## **BEALES HOTEL, COMET WAY, HATFIELD**

### **PROPOSED SECOND FLOOR TO PROVIDE ADDITIONAL ACCOMMODATION INCORPORATING A GYMNASIUM**

#### **DESIGN AND ACCESS STATEMENT**

### ***ADDENDUM***

scale 1:125 at A1 A05.229.P.008.B

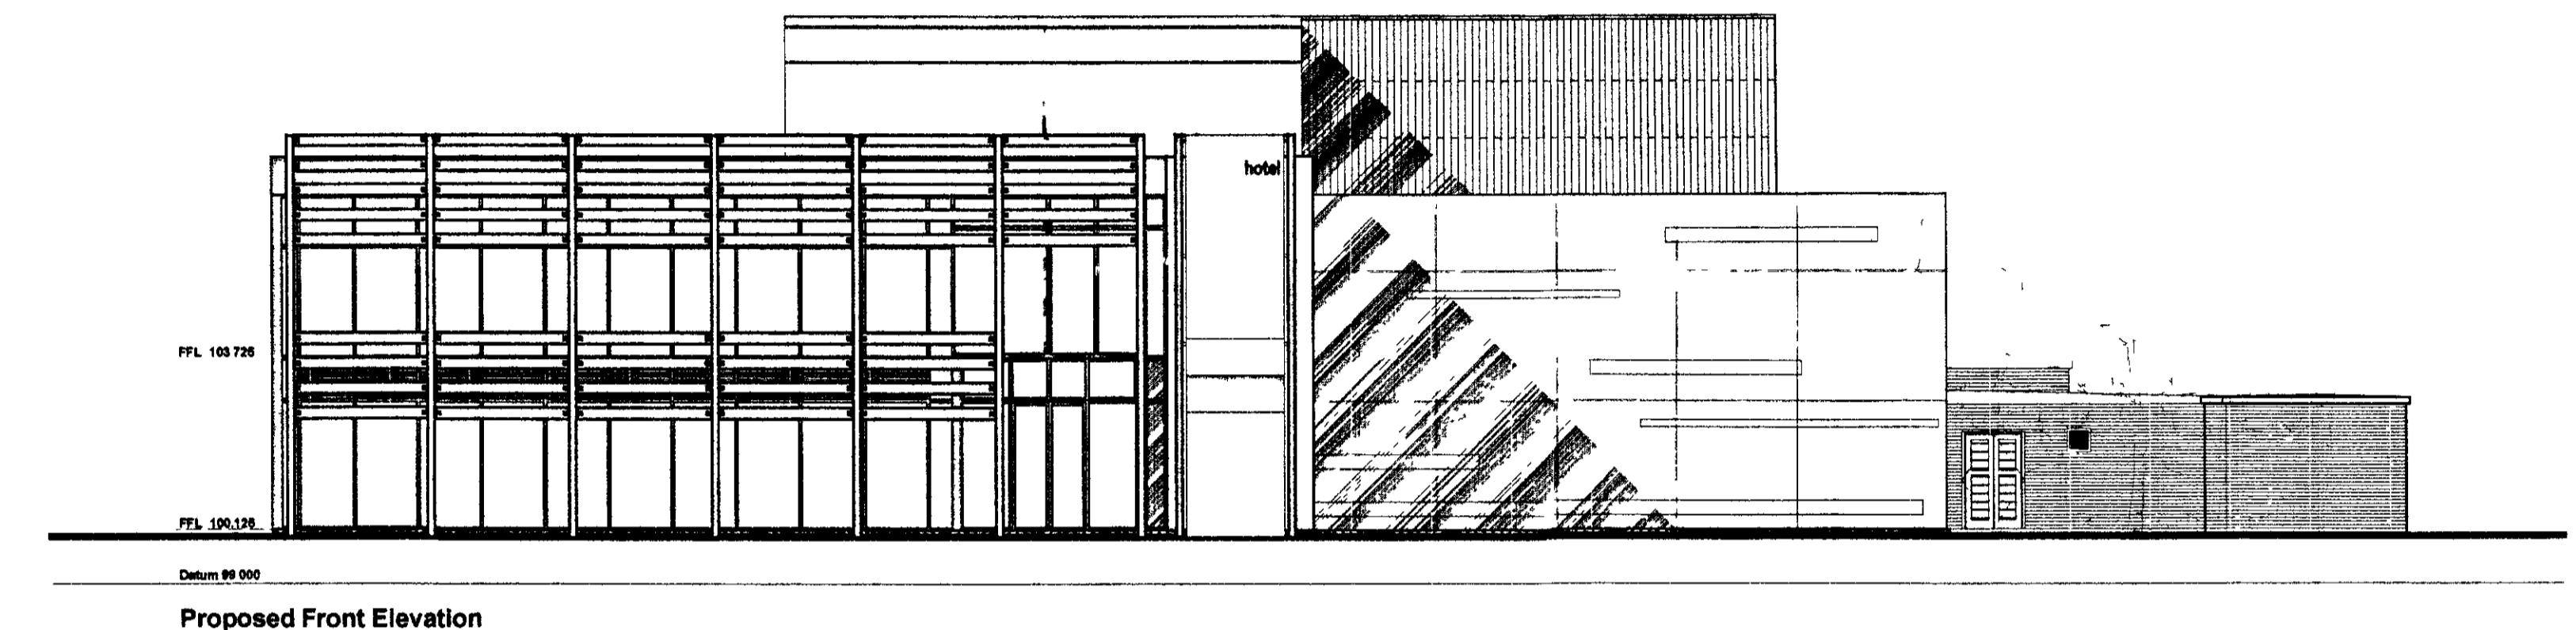
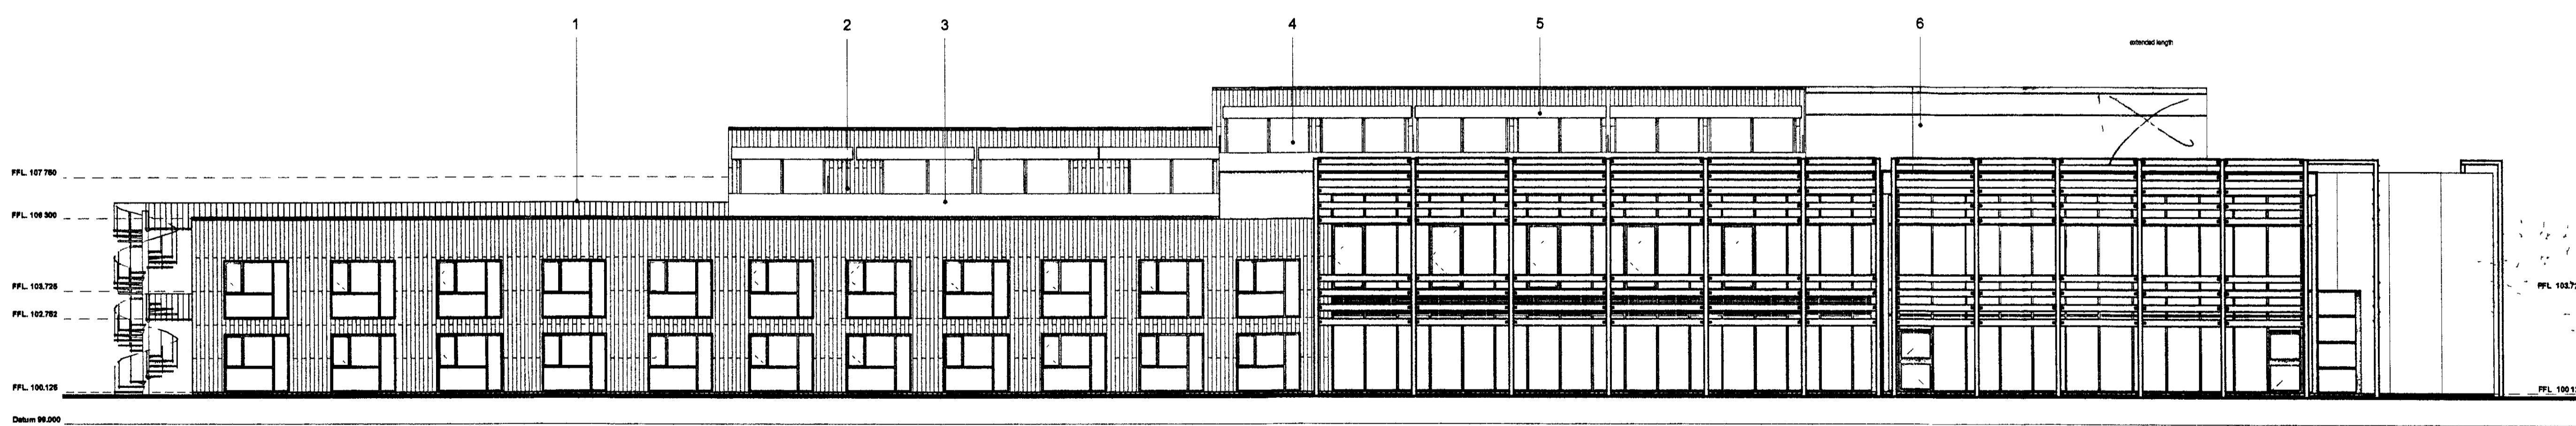
It is also proposed to increase the floor area of the gymnasium by approximately 74 square metres. This will involve a small increase in the massing at this level which is shown on attached drawing A05.229.P007D and elevations P008B & P009B.

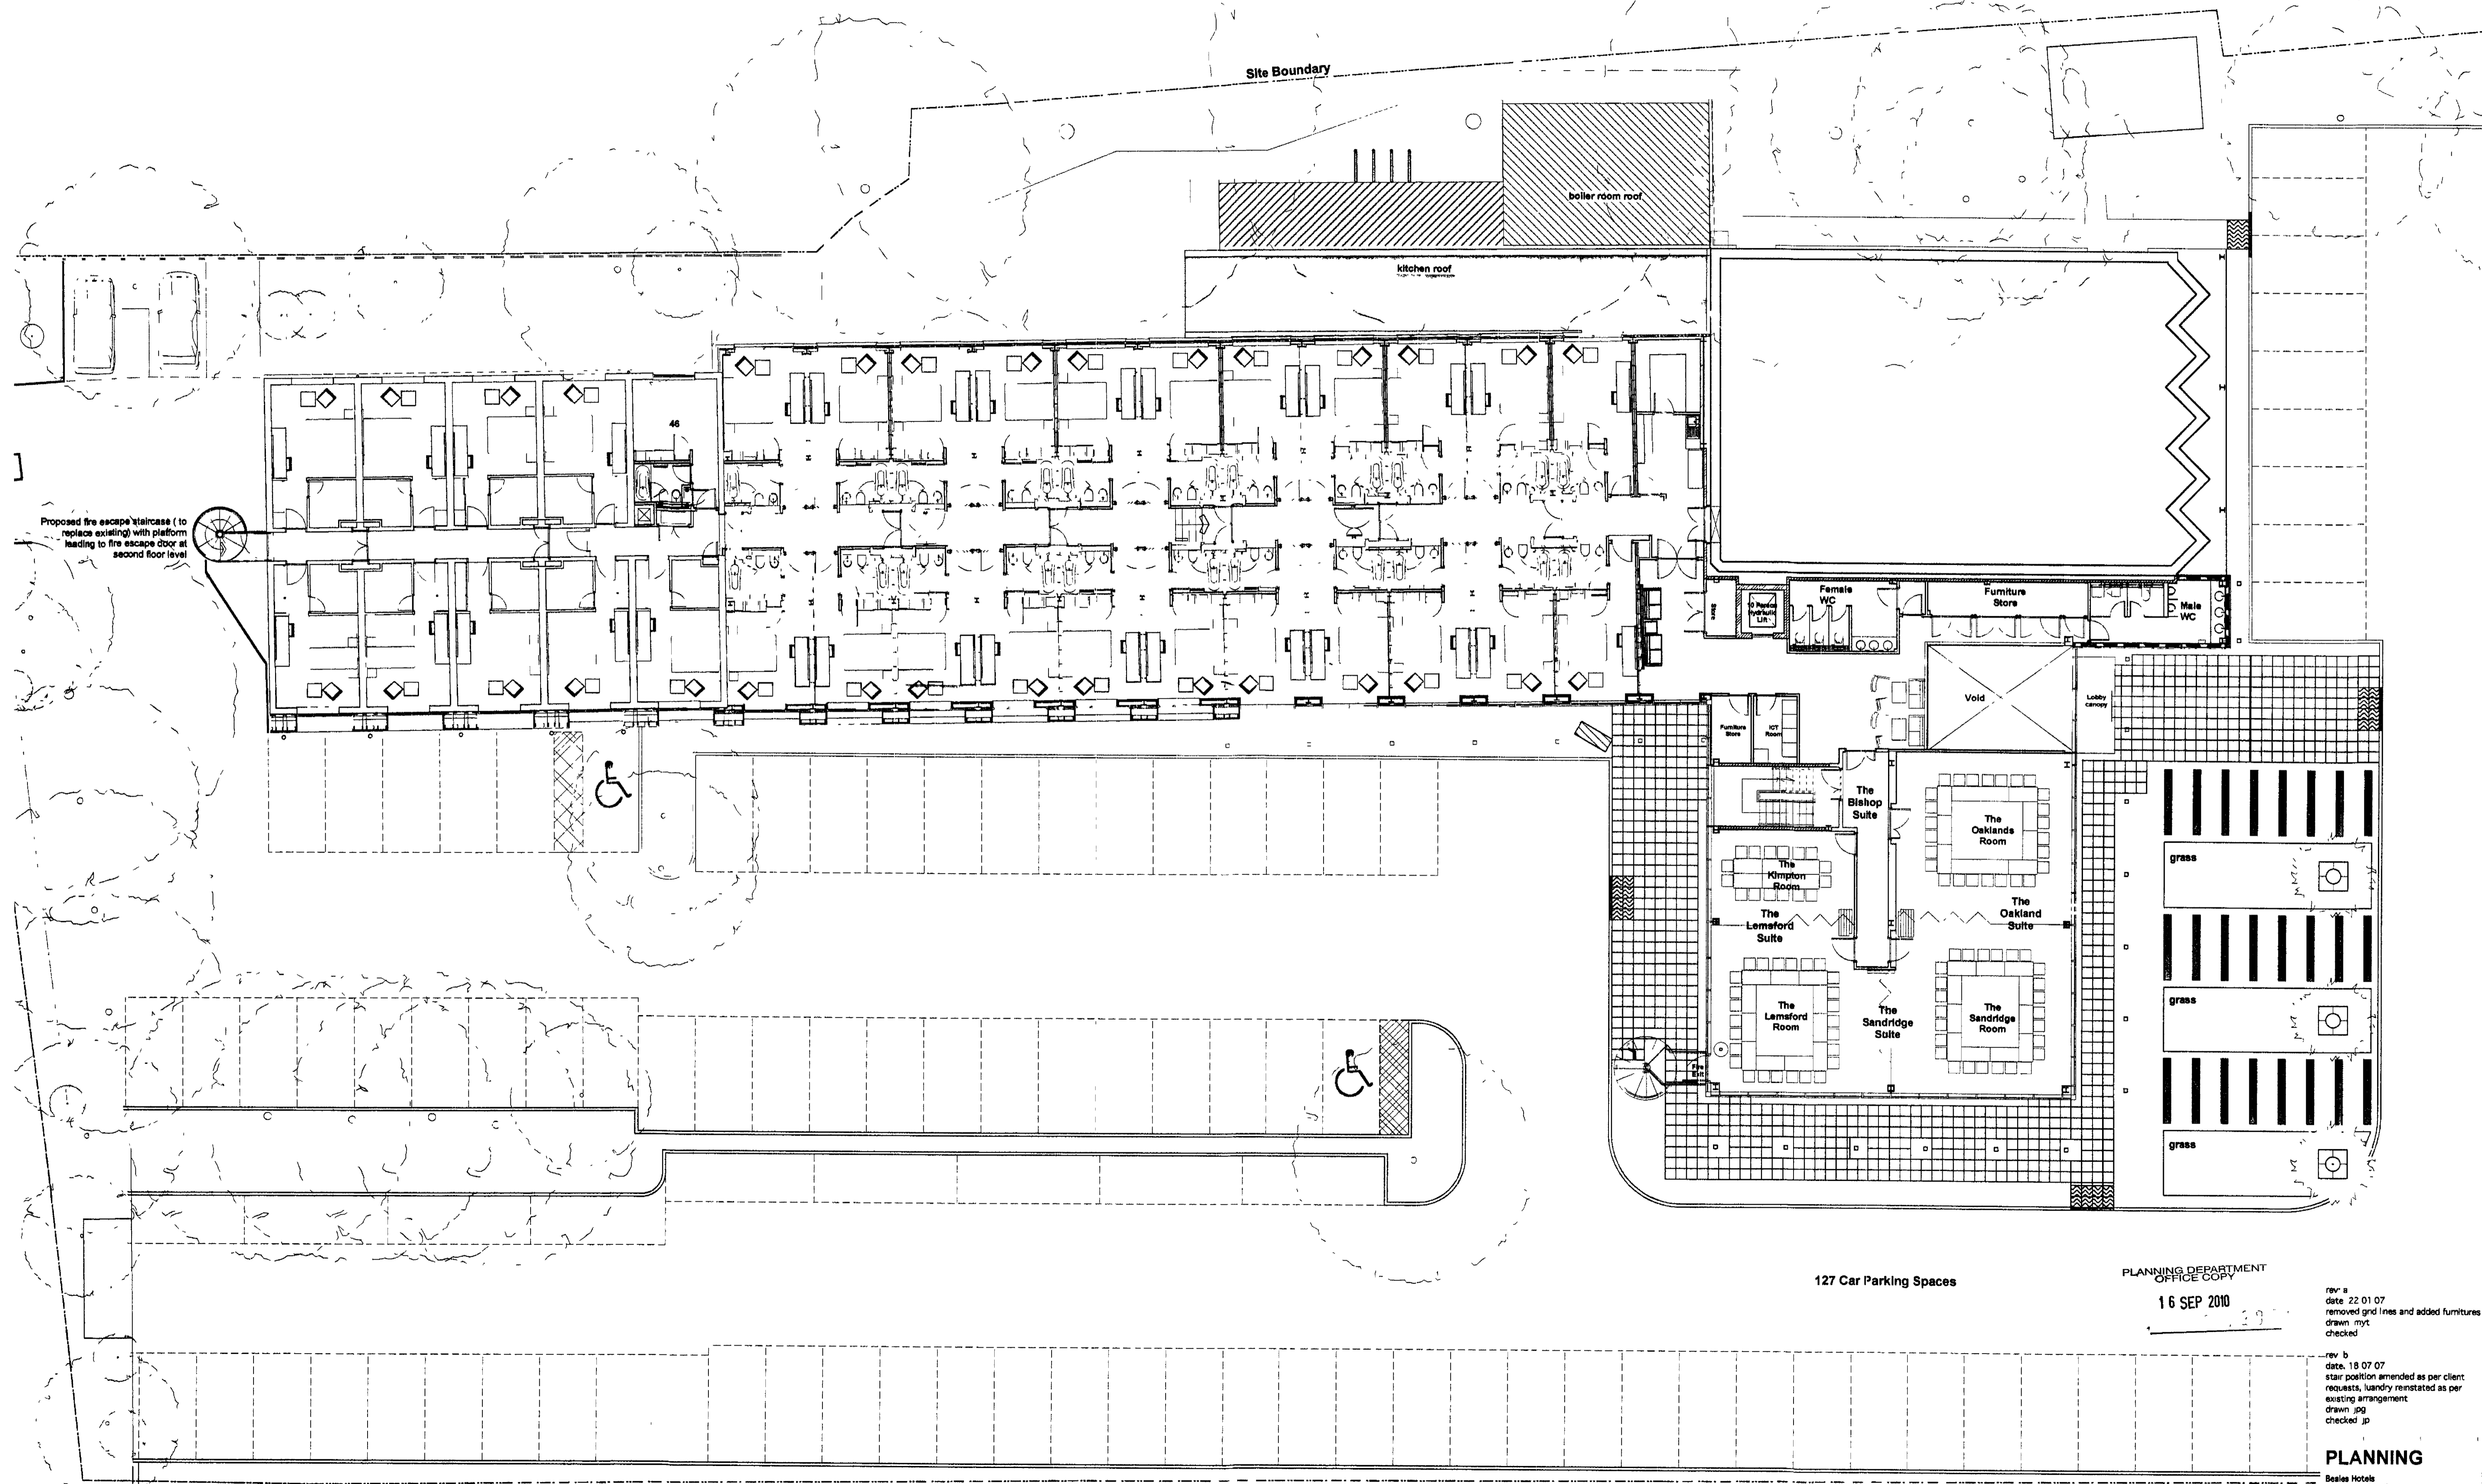
To remove the internal stairs and reinstate the laundry room as existing – refer to drawing A05.229.P006B;

scale 1:125 A05.229.SK.007.D

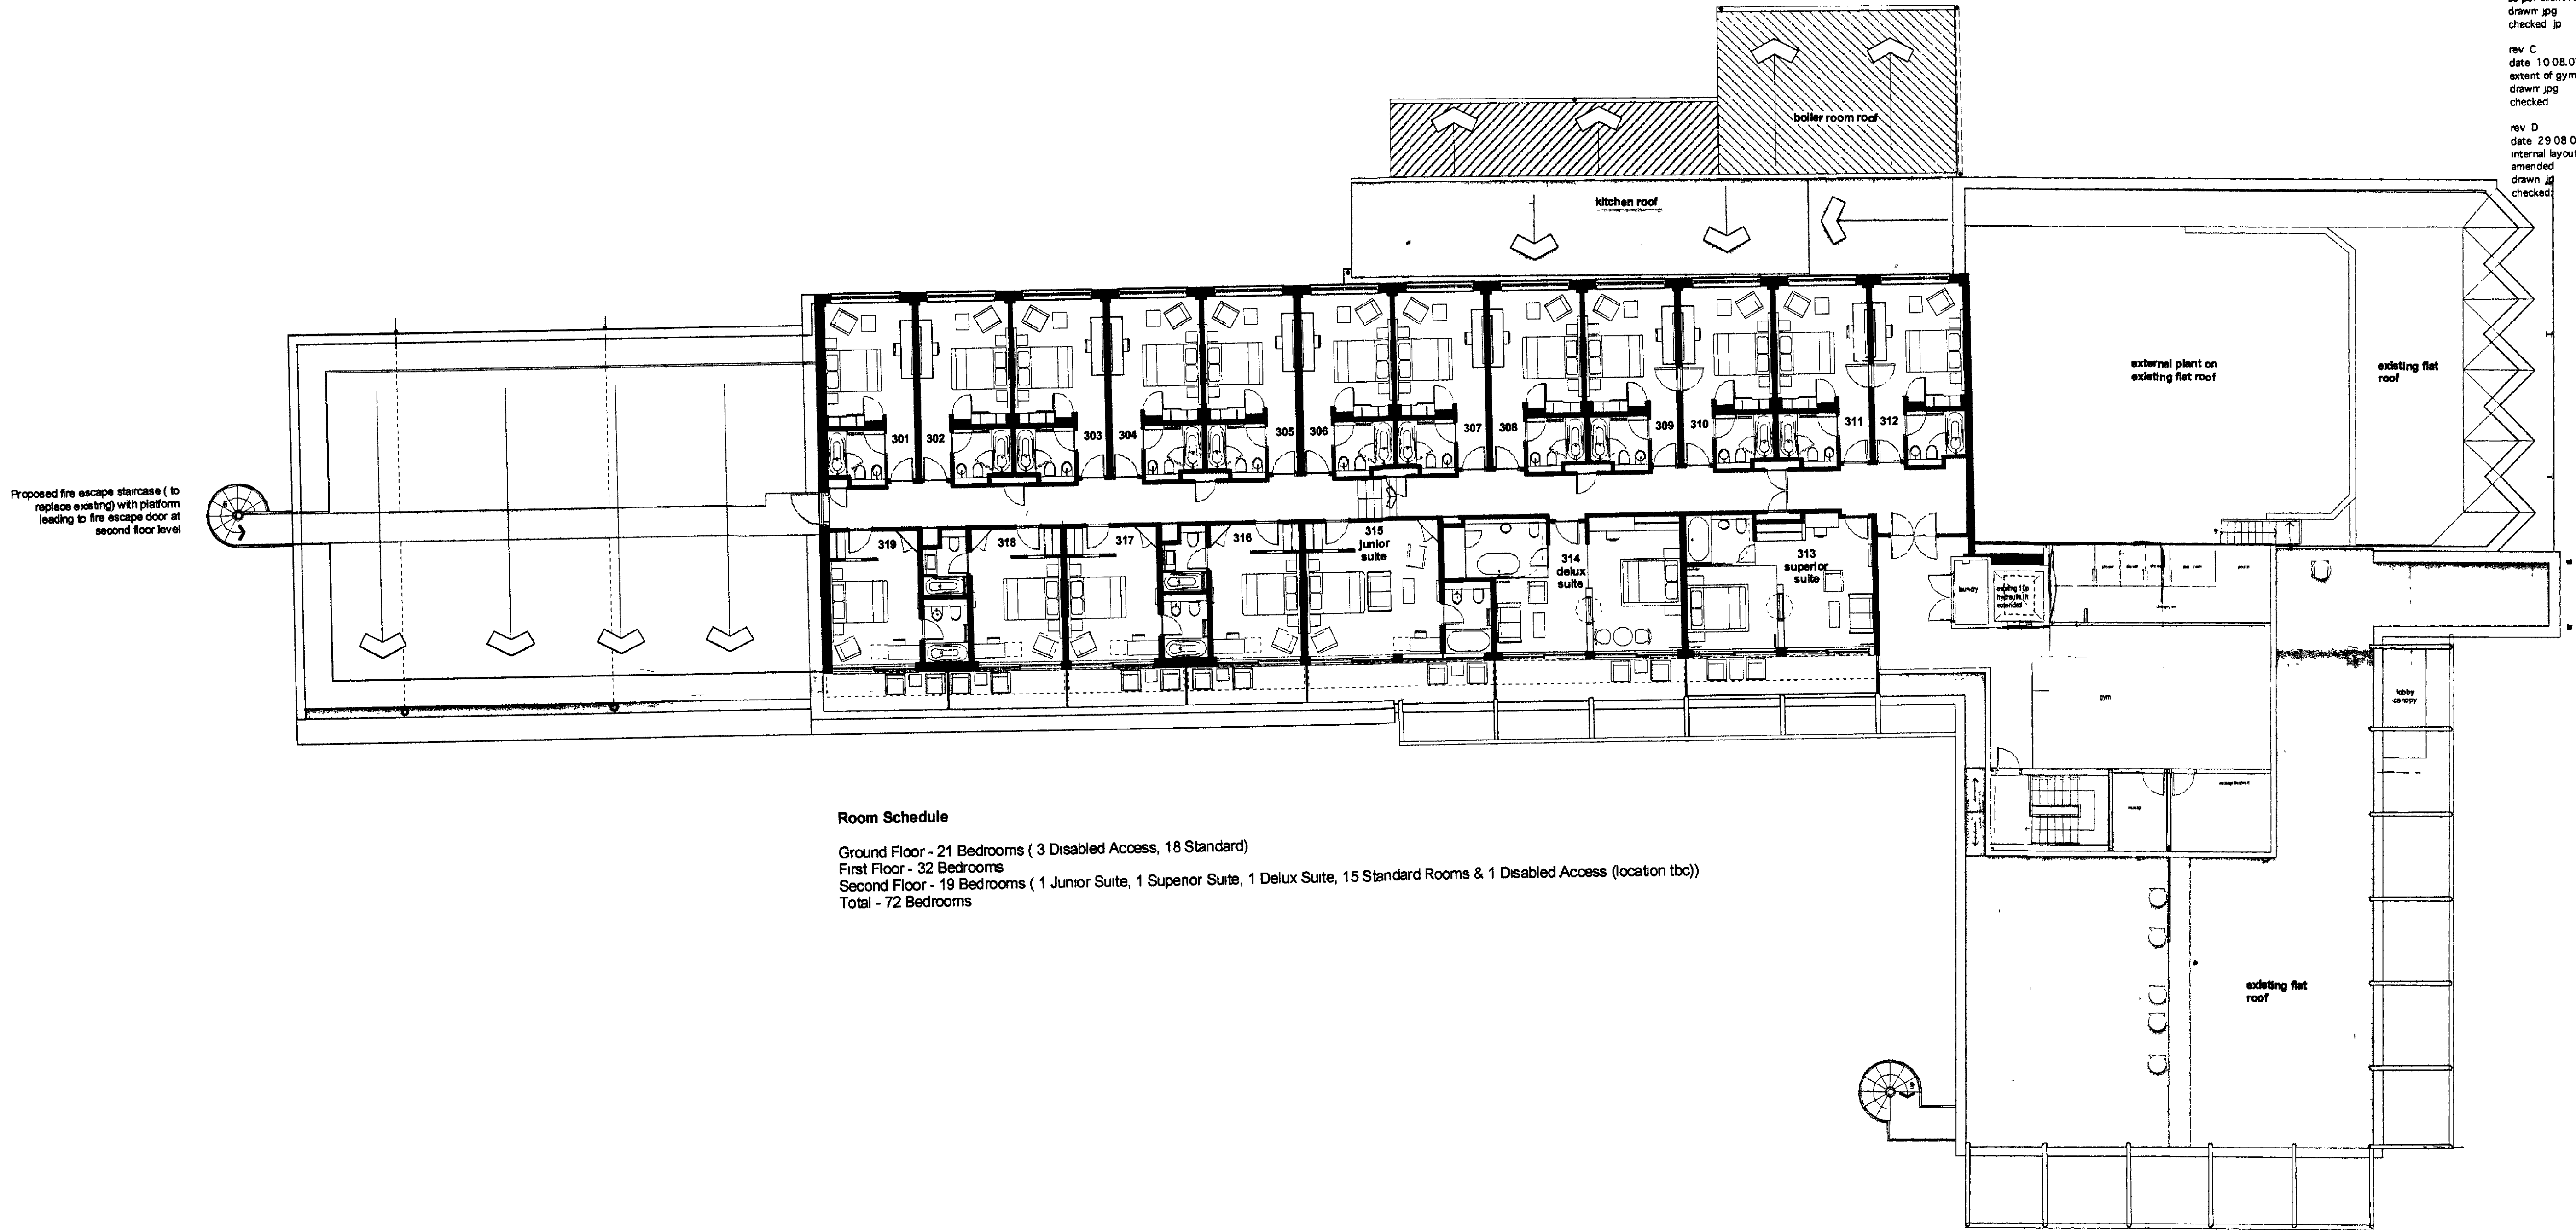
Without any change to the mass and footprint to this part of the building, increase the number of bedrooms by three to a total of 72. This be achieved by including a new bedroom (above the laundry room on the first floor) and subdividing two deluxe suites to provide 4No standard bedrooms – refer to drawing A05.229.P007D.

We have already referred to the removal of the stairs to reinstate the laundry room at first floor level and a new bedroom at second floor level. In their place, the existing stairs that serve the conference suites at first floor level will be extended to the second floor, providing access to both the gymnasium as well as serving as a fire escape route.
